## Application for Removal or Variation of a Condition following Grant of Planning Permission or Listed Building Consent

Demolition of existing dwelling and erection of replacement dwelling and detached garage, associated landscaping and driveway alterations

23/01854/FUL

Based on current Planning Approval 23/01854/FUL

Proposed Site Plan

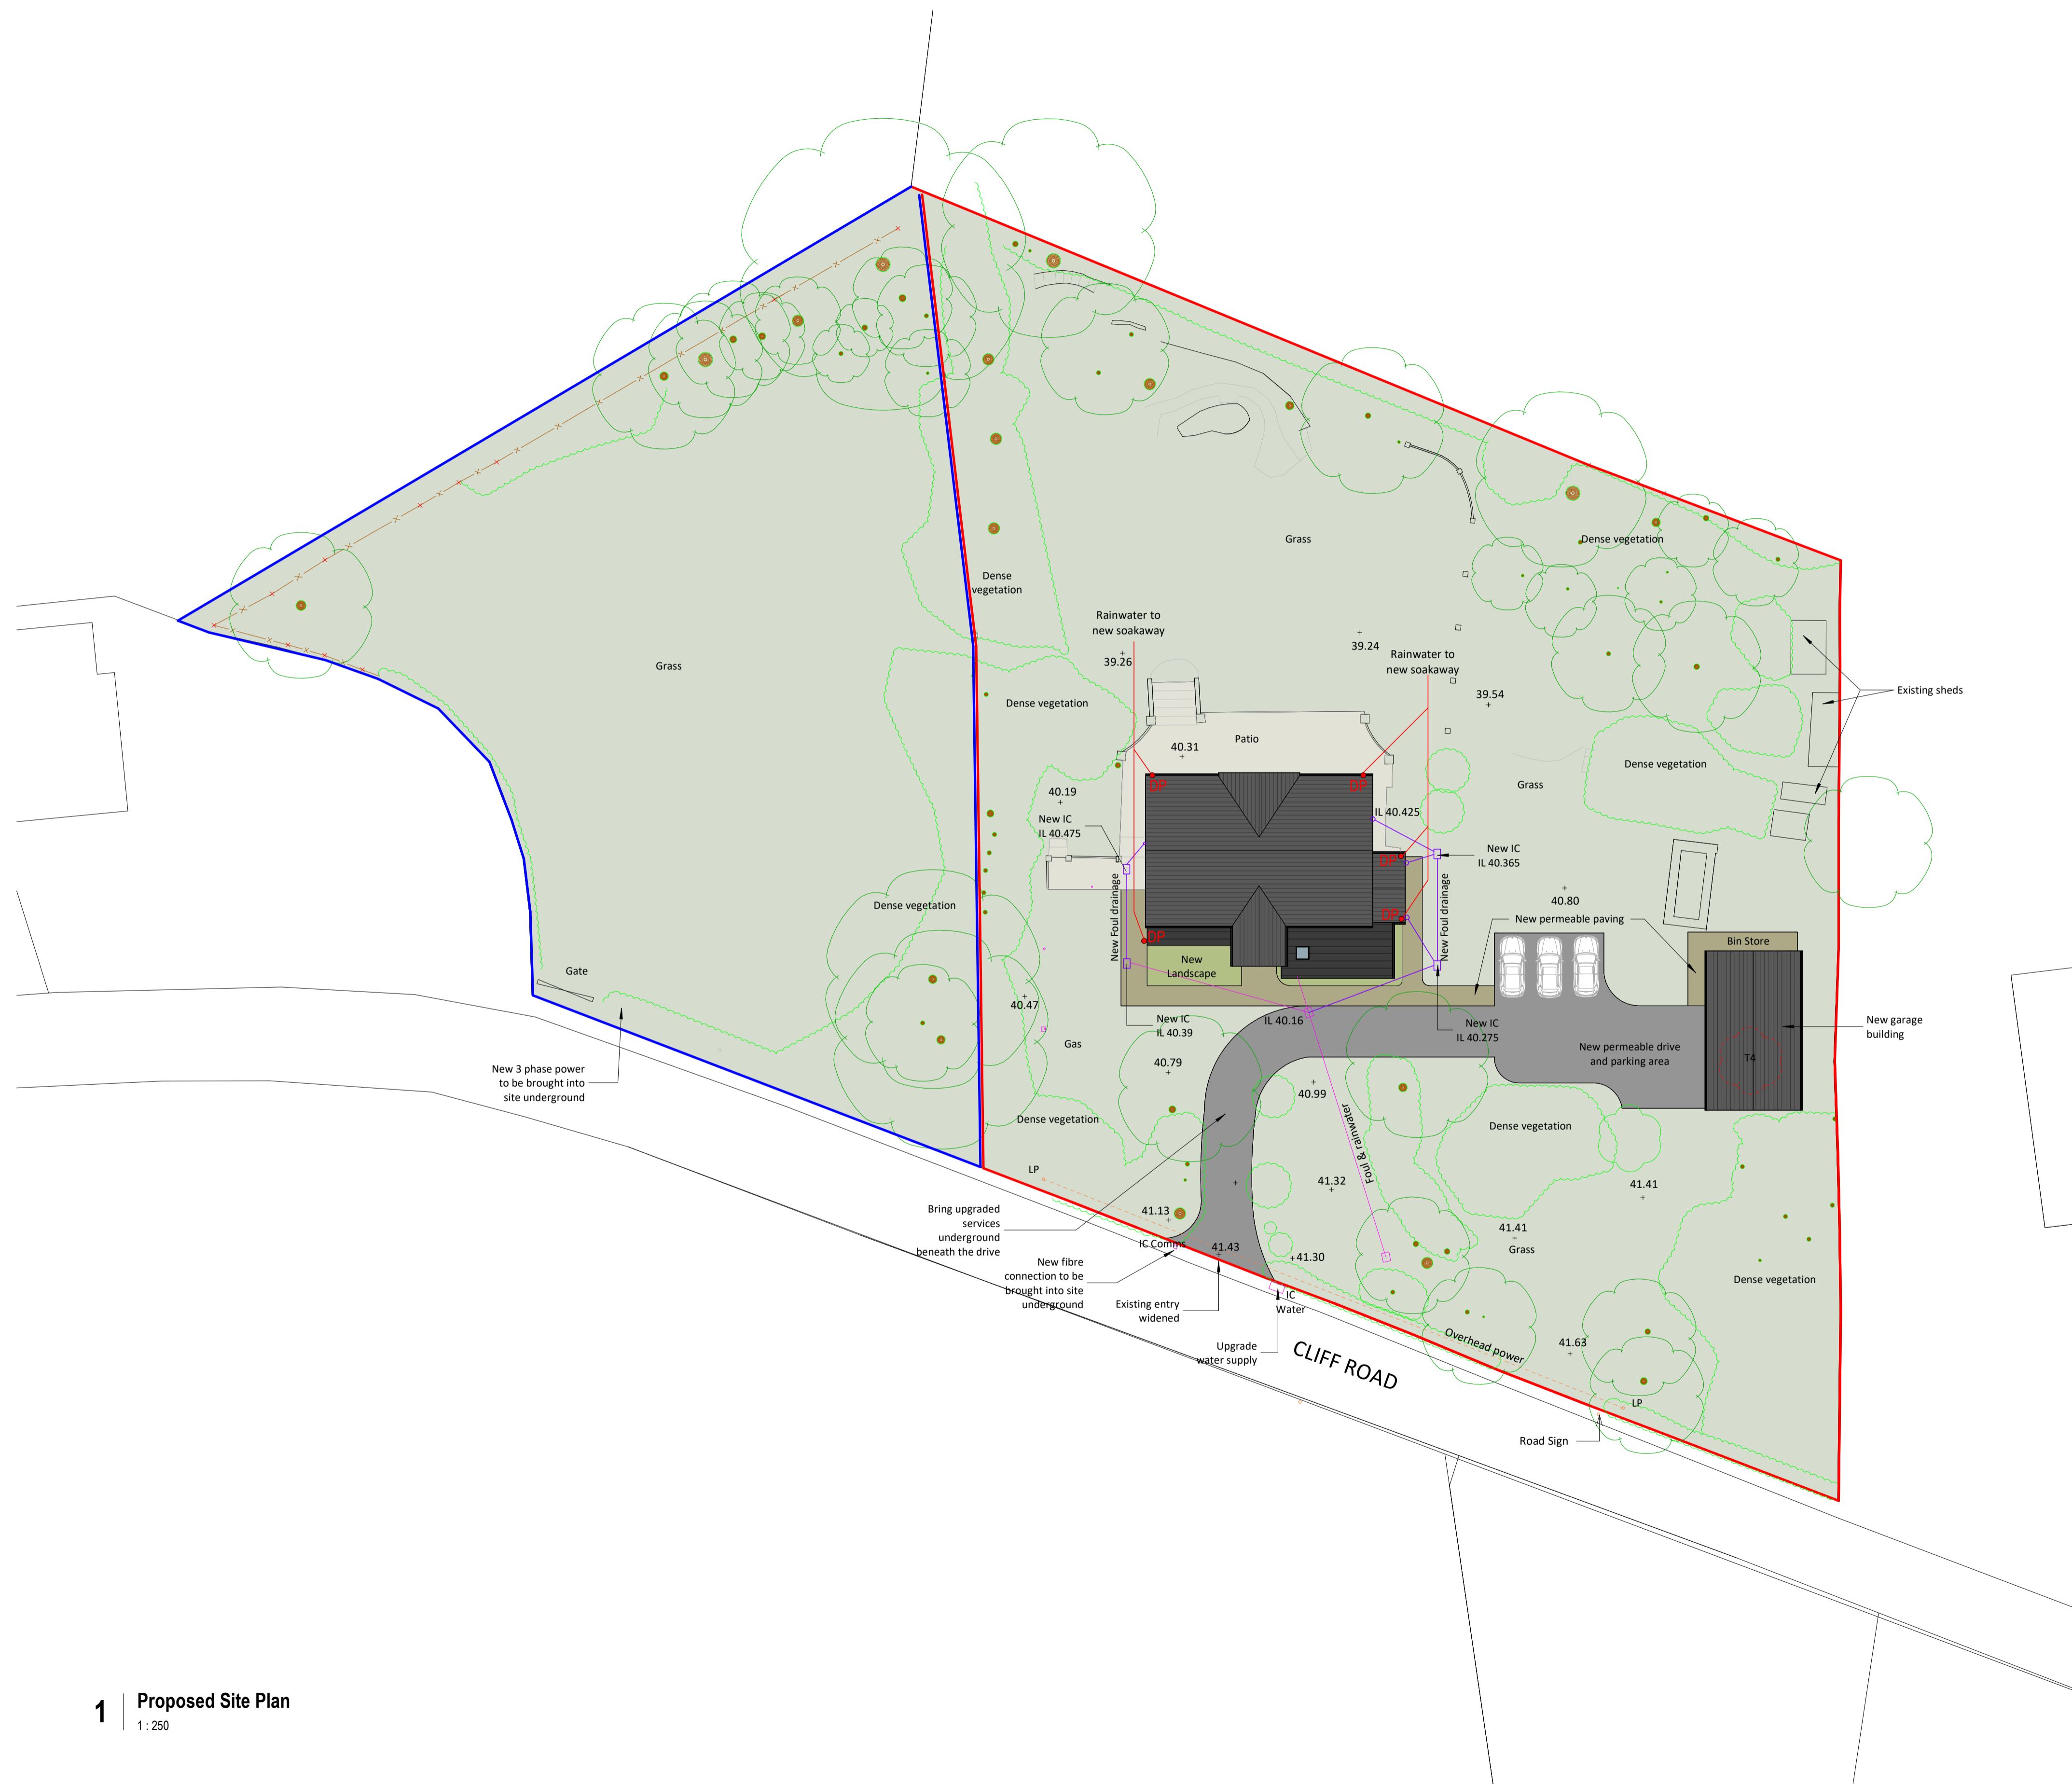
Condition 2 - Small section of the single storey ground floor side elevation will now not be built reducing the size of the replacement building by approximately 69 sq. metres

Condition 2 - should just say that 'the development hereby approved should be carried out in accordance with the revised plans submitted with the application.' In this instance, this covers the following revised drawings, which are attached to this application:

- 1) Proposed Site Plan (6545-02 Rev D)
- 2) Floor Plans (6545-03 Rev D)
- 3) Roof Plans (6545-04 Rev D)
- 4) Proposed Elevations (6545-06 Rev D)

Title  
Floor Plans

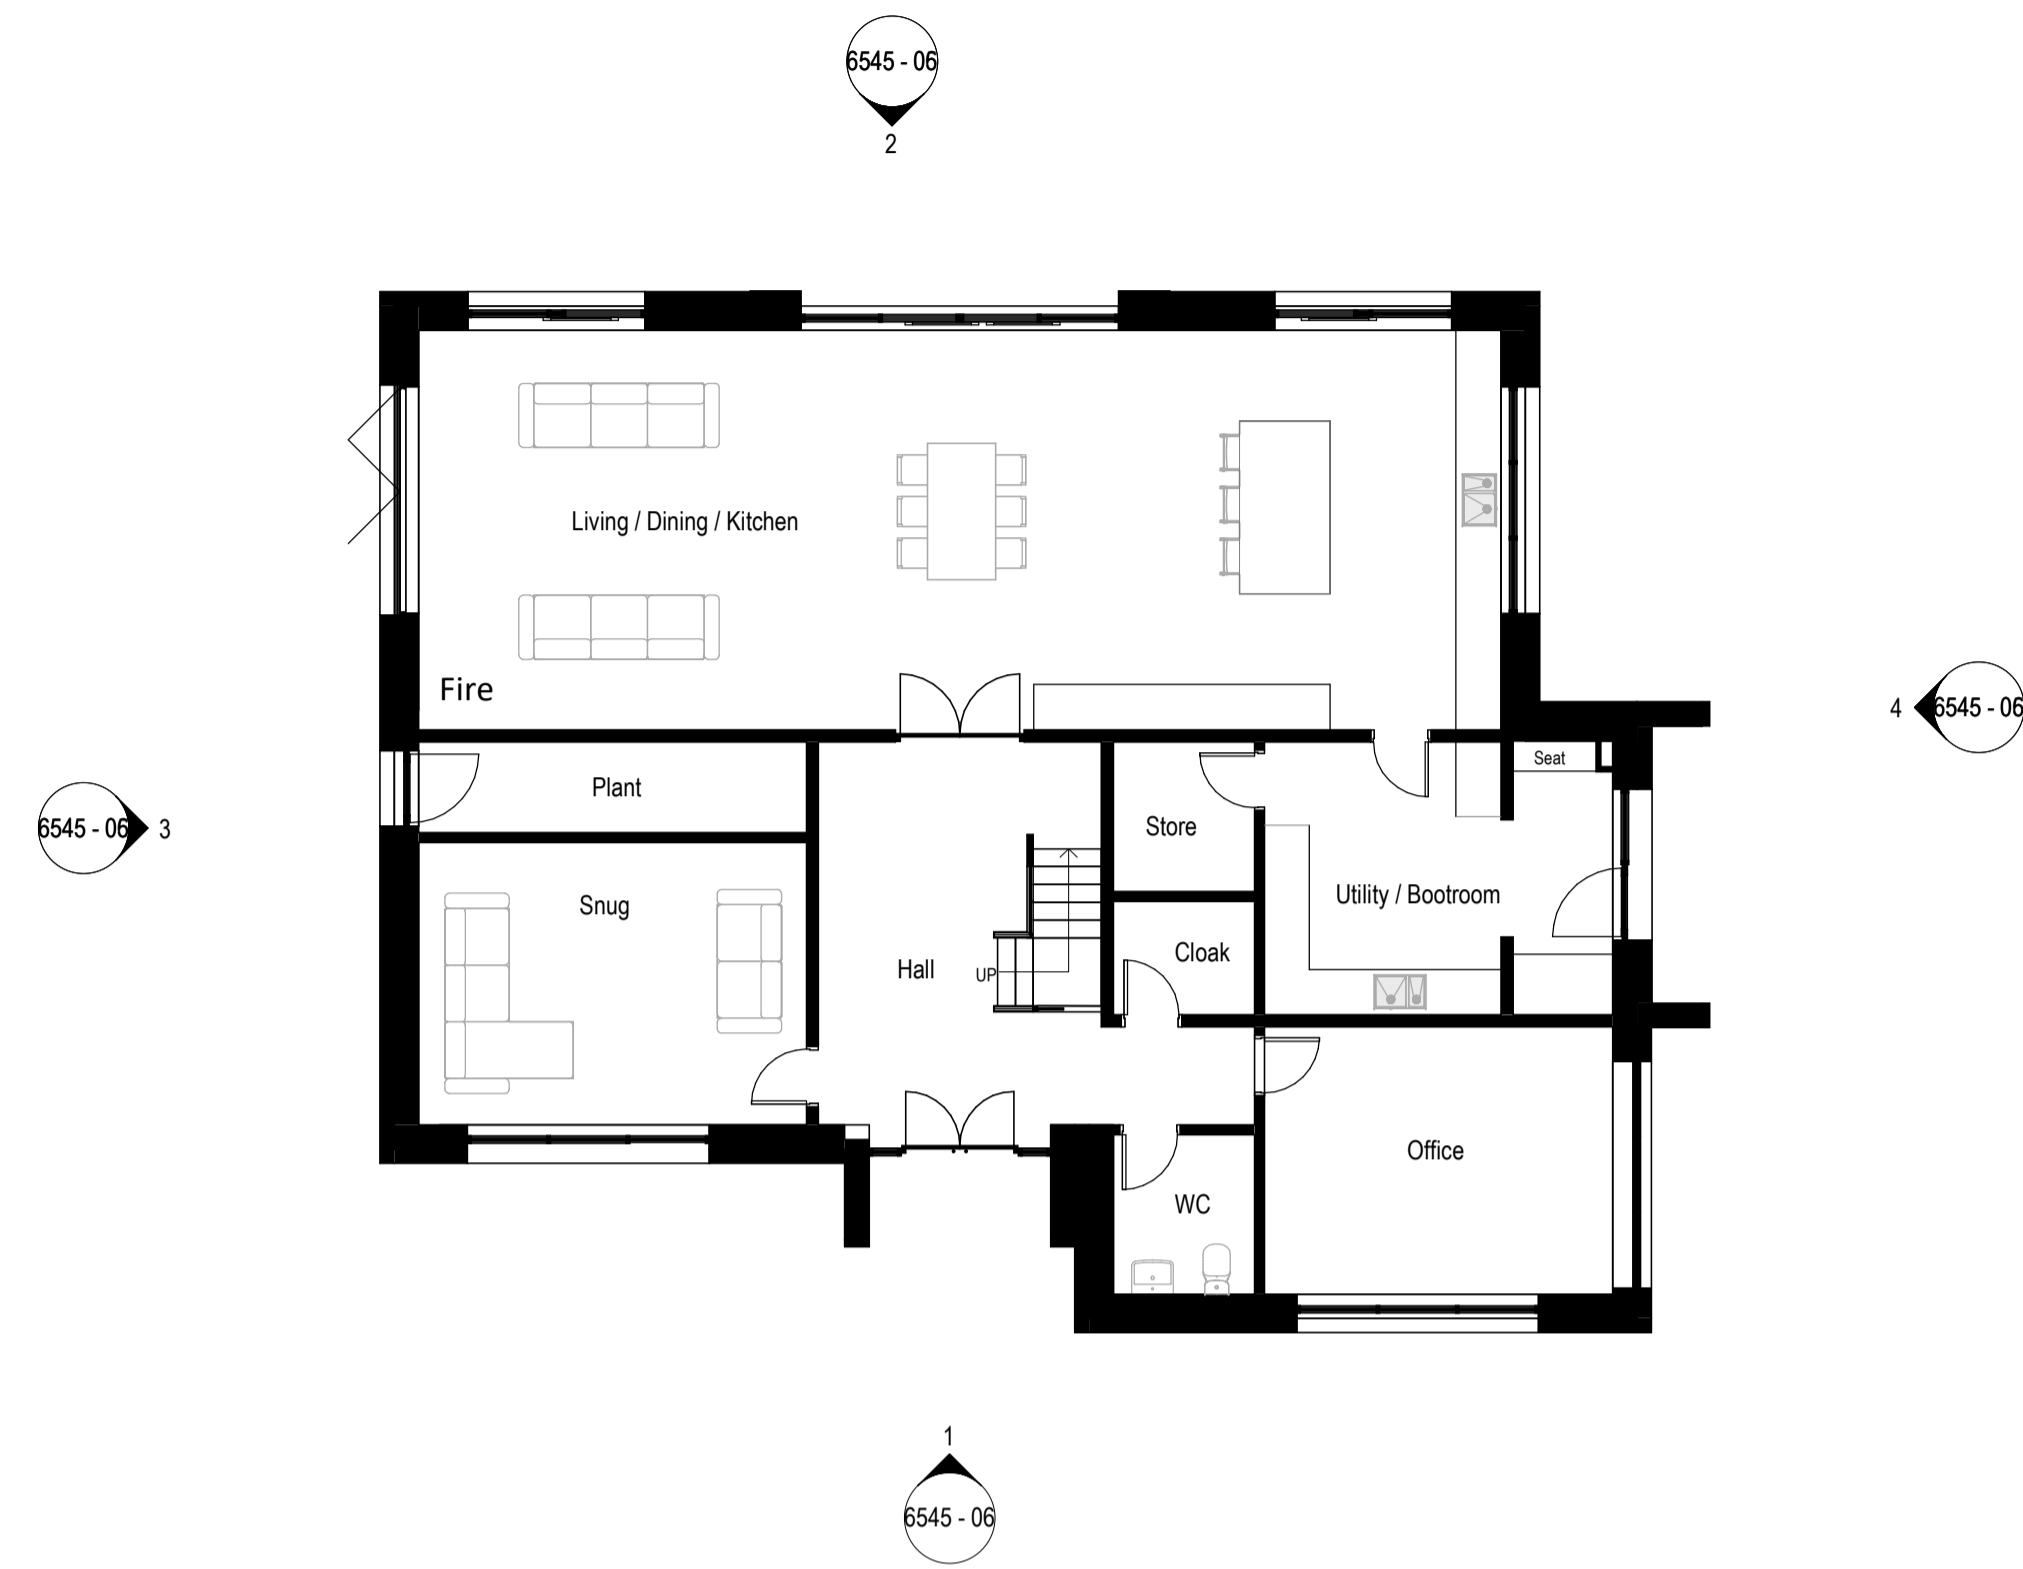
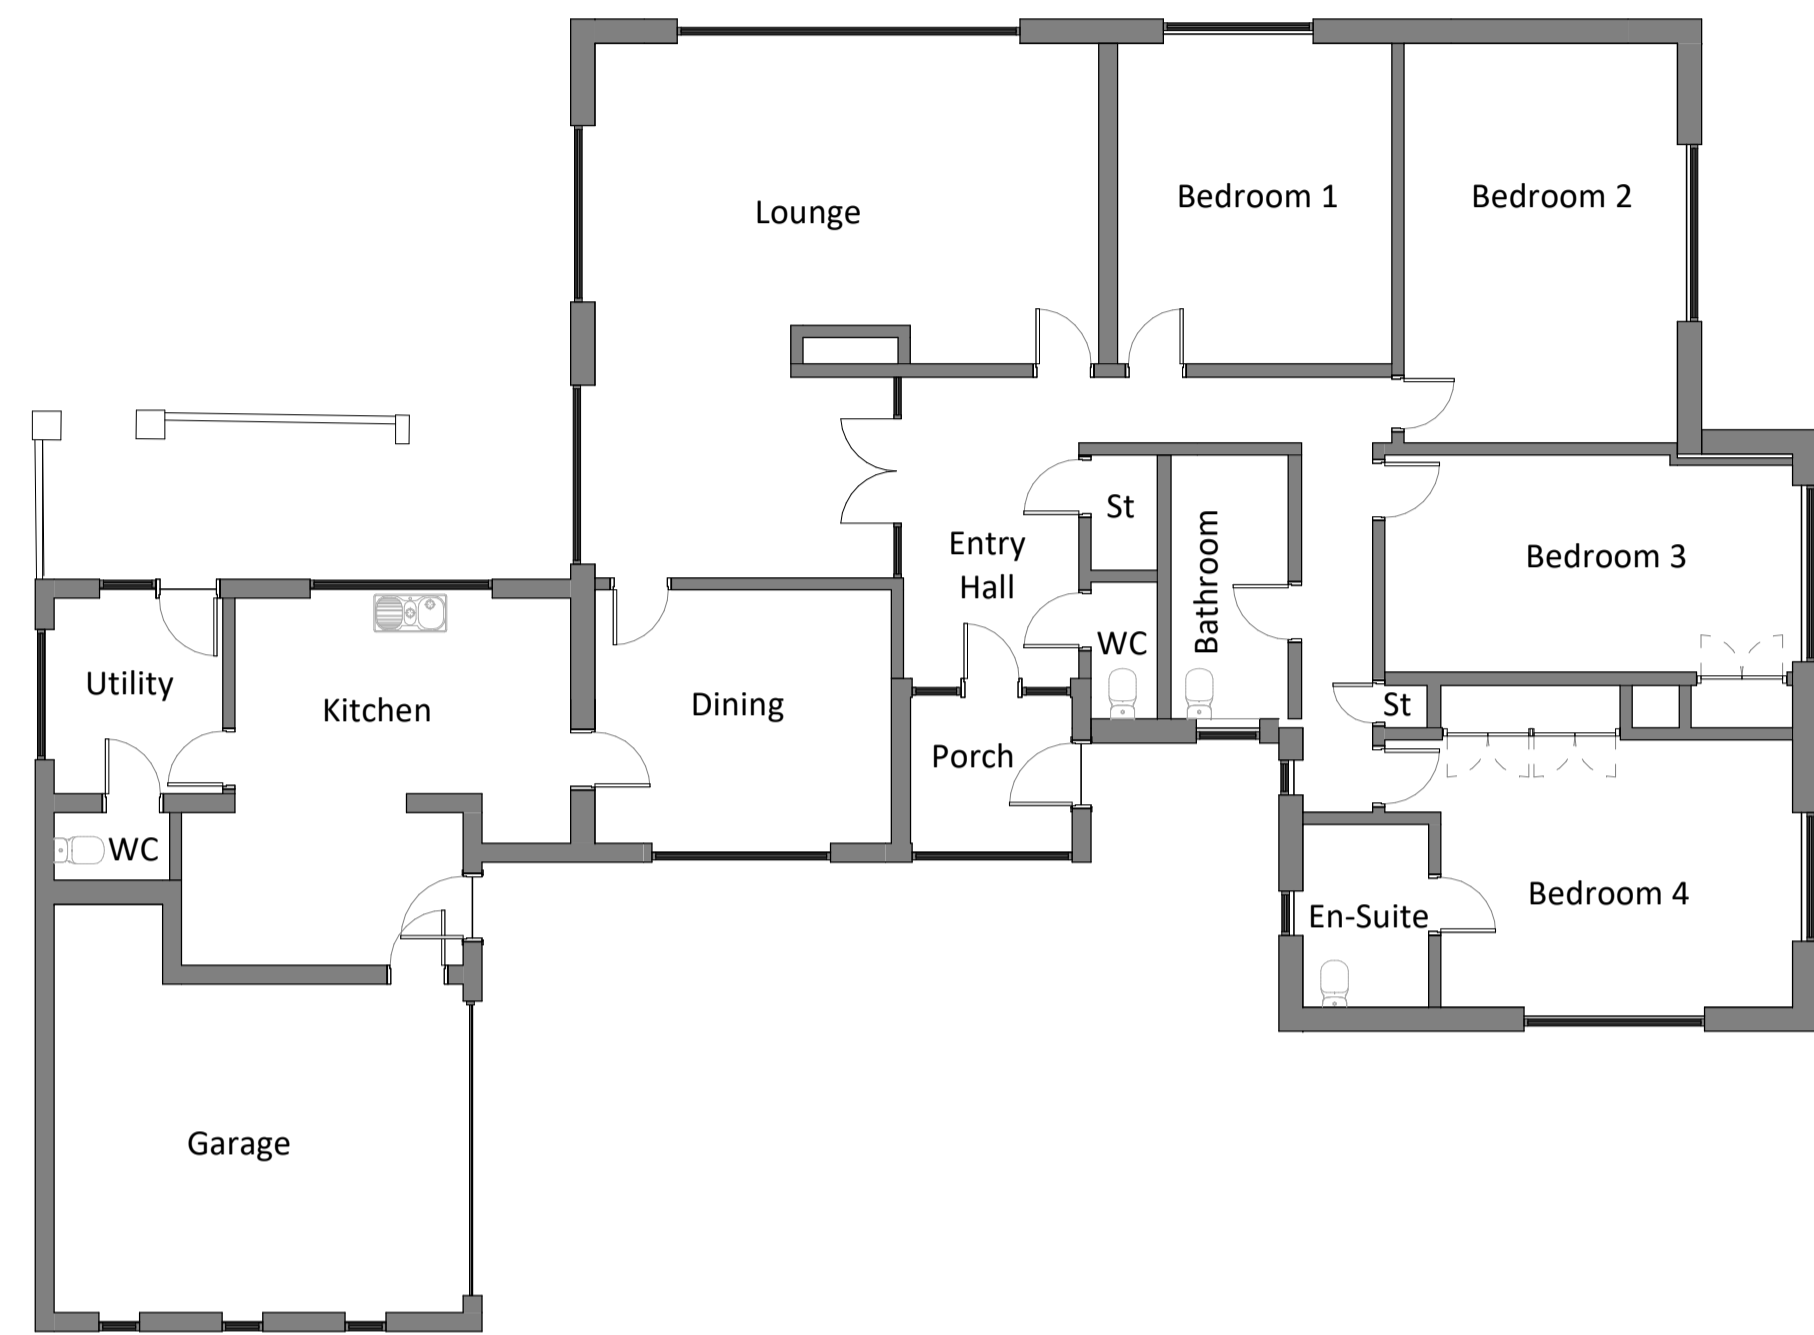
Condition 2 - Some windows made smaller on side elevation, an outside door added to plant room, minor internal floor plan changes and fewer glass panes in two windows but no size increase, plus opening roof light added to flat roof w.c.
